Rezoning Transportation Analysis
Petition Number: Insert Zoning Petition #2021-258
General Location Identifier: 04739101

Date	Description
04-28-22	First Review (PDM)

REZONING SITE PLAN

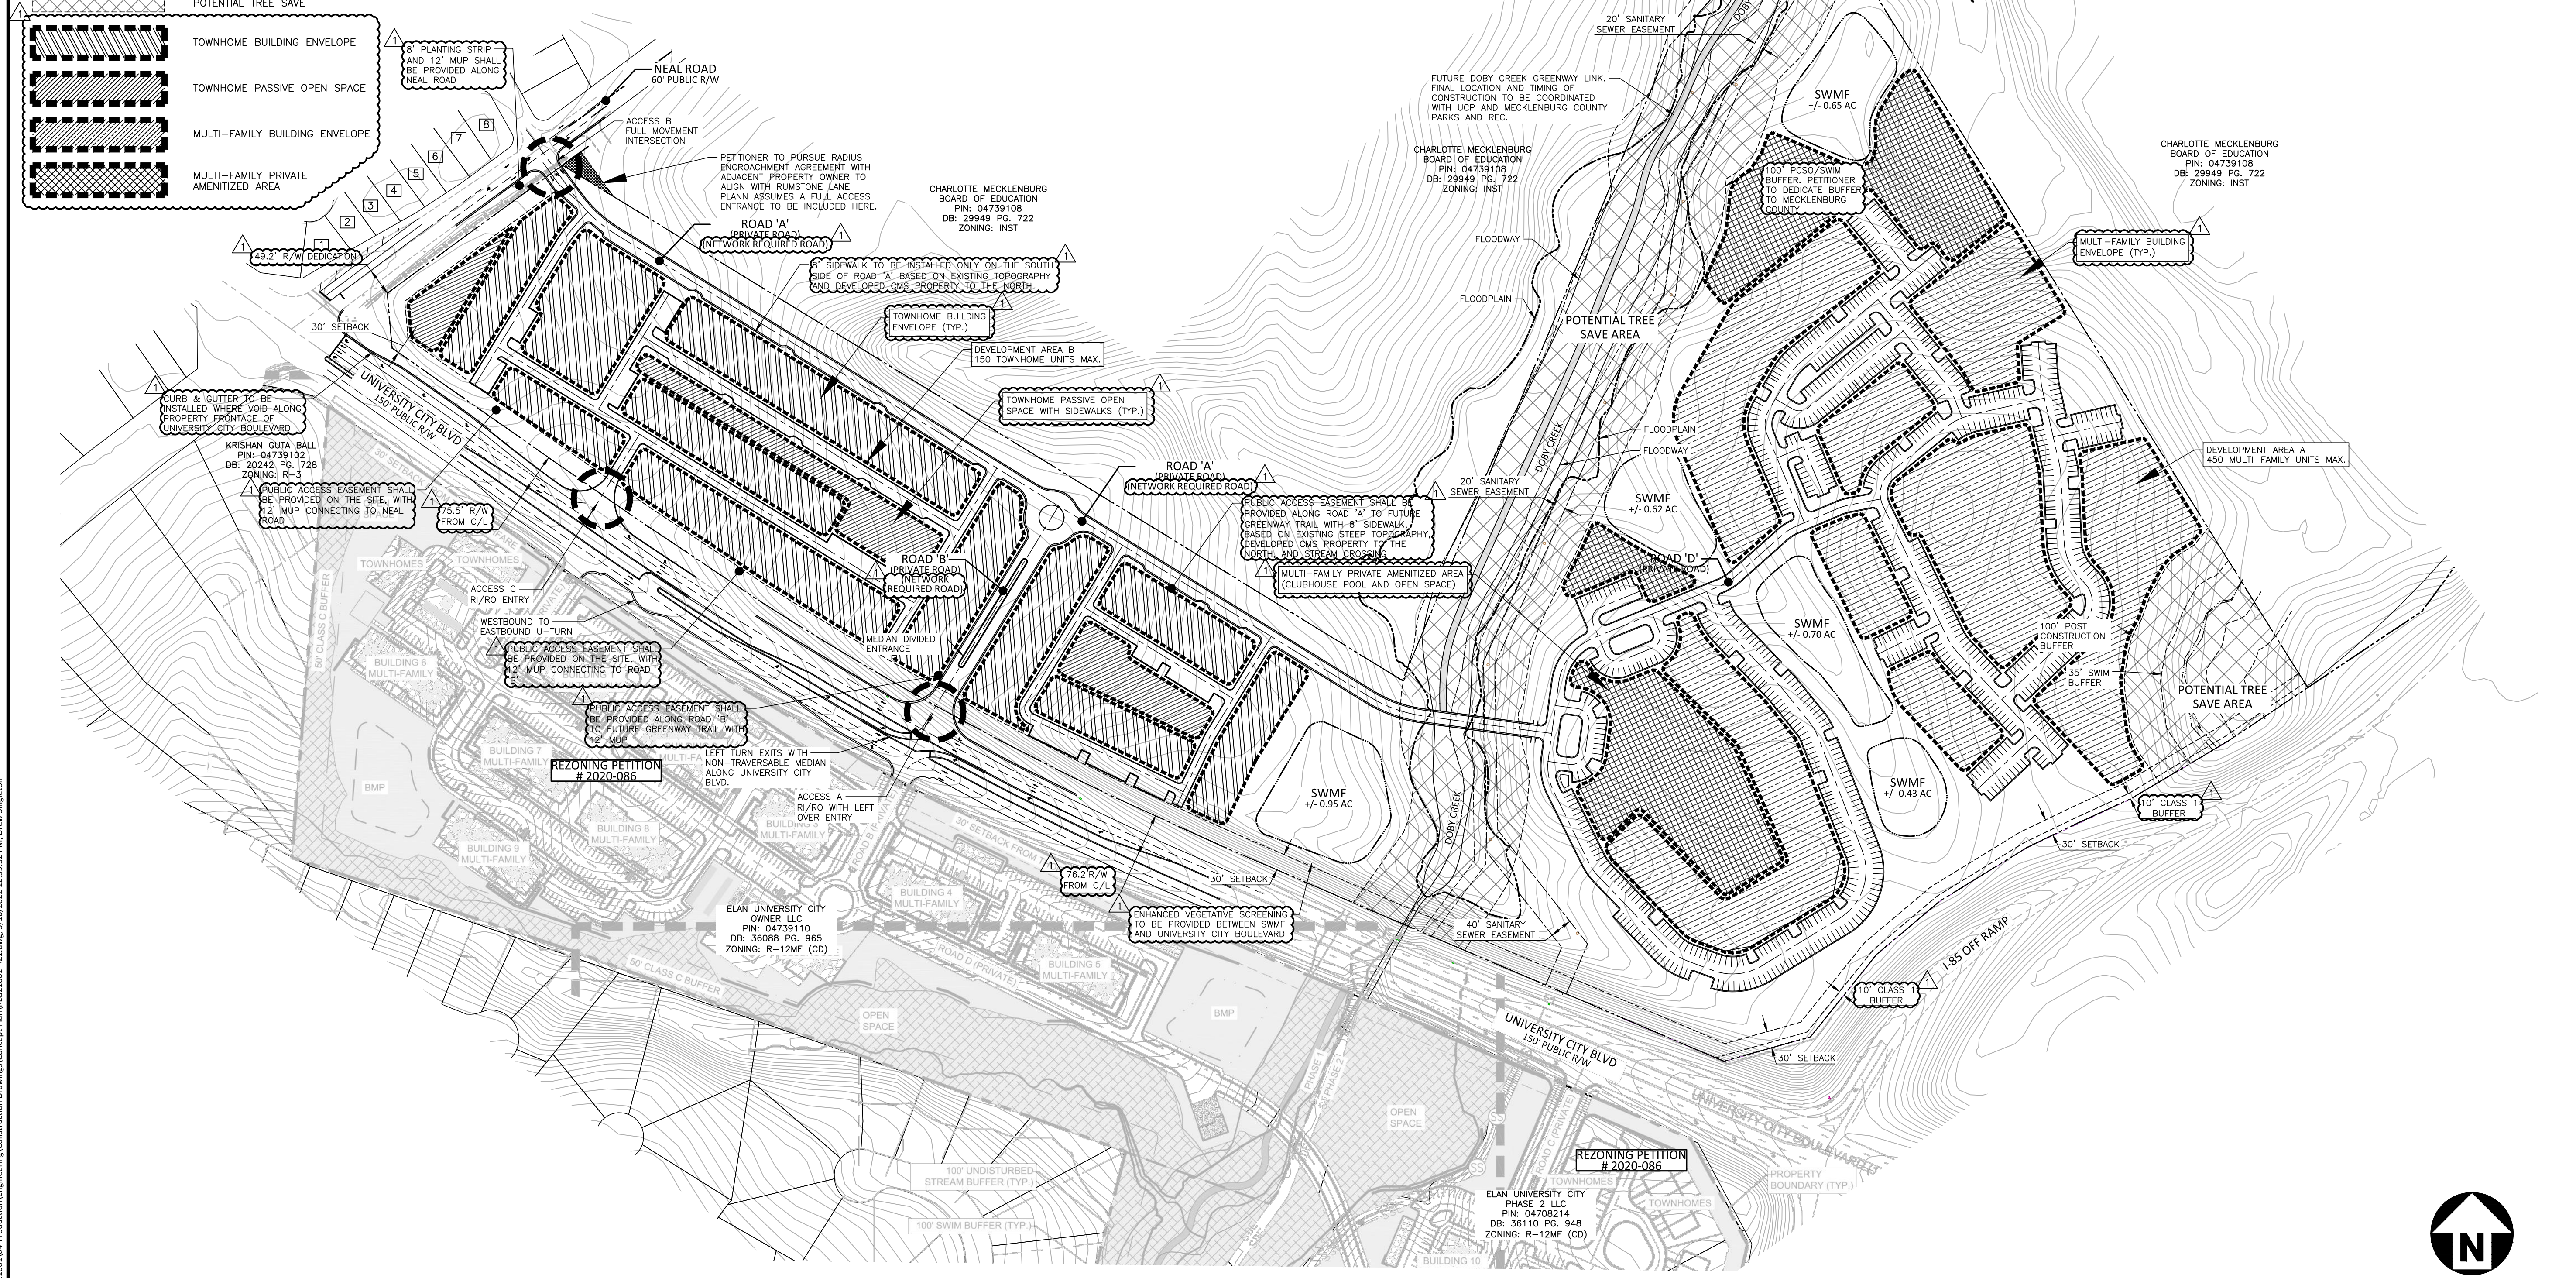
2. Revise site plan and conditional note(s) to commit to installing all recommend transportation improvements outlined in the approved traffic study sealed on March 2, 2022. The conditional notes should describe each scenario analyzed in the study and should commit to installing all improvements for each scenario as outlined in the Traffic Impact Study.

- Construct an additional southbound left turn lane on Neal Road with 190 feet of storage utilizing the existing pavement width where available and ensure the northbound and southbound left turn signal phasing run concurrently

- One ingress and one egress lane (a terminating southbound right turn lane on proposed Access "A")
- Construct a westbound right turn lane on University City Boulevard with 100 feet of storage
- 100-foot internal protected stem

- One ingress and one egress lane (a terminating southbound right turn lane on proposed Access "A")
- Construct a westbound right turn lane on University City Boulevard with 100 feet of storage
- Construct an eastbound left turn lane on University City Boulevard with 250 feet of storage
- 100-foot internal protected stem

- One ingress and two egress lanes (a combined westbound thru-right turn lane and a separate westbound left turn lane with 100 feet of storage on Access "B")
- Remark existing painted median for southbound left turn lane on Neal Road and maximize storage
- 100-foot internal protected stem

- Construct an adequate westbound U-turn lane on University City Boulevard with 225 feet of storage designed to accommodate an SU-30 at the minimum

- One ingress and one egress lane (a terminating southbound right turn lane on proposed Access "C")
- Construct a westbound right turn lane on University City Boulevard with 100 feet of storage
- 100-foot internal protected stem

3. Revise site plan and conditional note(s) to commit to dedicate 35-foot right-of-way from the road centerline on Neal Road. The site plan shall label and dimension the right-of-way from the road centerline.

4. Revise site plan to label and dimension the right-of-way on University City Boulevard from the road centerline.
5. Revise site plan and conditional notes to commit to installing a 12-foot multi-use path along the entire property frontage of University City Boulevard per Chapter 19 and 20 of the City Ordinance. The multi-use path should be located outside of the limits of the NCDOT controlled access/right-of-way and should be located within a sidewalk utility easement. The multi-use path also meets the requirements outlined in the council adopted Charlotte WALKS and Charlotte BIKES policies. A transition will need to be provided at the intersection of Neal Road to transition bicyclist from the multi-use path to the existing on-street bike lane facilities west of Neal Road.

6. CDOT **RECOMMENDS** revising the site plan and conditional notes to commit to installing a traffic signal at the intersection of University City Boulevard and proposed Entry #1 with a two-stage z-crossing for pedestrians. The traffic signal is recommended by CDOT, NCDOT and Mecklenburg County to provide a safe pedestrian crossing across University City Boulevard. In addition to general vehicular and pedestrian traffic, pedestrian traffic from the proposed Doby Creek Greenway will use this intersection to cross University City Boulevard.

7. Site plan and conditional note(s) revisions are needed to commit to construct bicycle facilities on Neal Road by installing a 12-foot multi-use path to meet the City Charlotte BIKE Policy.
8. Revise conditional note C.3 to reflect that any driveway adjustment must be approved by CDOT and NCDOT.
 2. The Site will be served by internal private streets, drives and alleys. Minor adjustments to the locations of the internal private streets, drives and alleys shall be allowed during the construction permitting process.
 3. Entry # 1 shall be a median divided entrance.
9. Site plan and conditional note(s) revisions are needed to commit to installing curb and gutter along University City Boulevard per Chapter 19 Ordinance. Curb and gutter is required to be installed in the missing section near the intersection of Neal Rd.

10. Revise site plan and conditional note(s) to provide the typical sections for all internal private roads. CDOT recommends using the location residential median street typical section with 8-foot sidewalks per CDLSM U-02. Sidewalks will be required along all private streets.
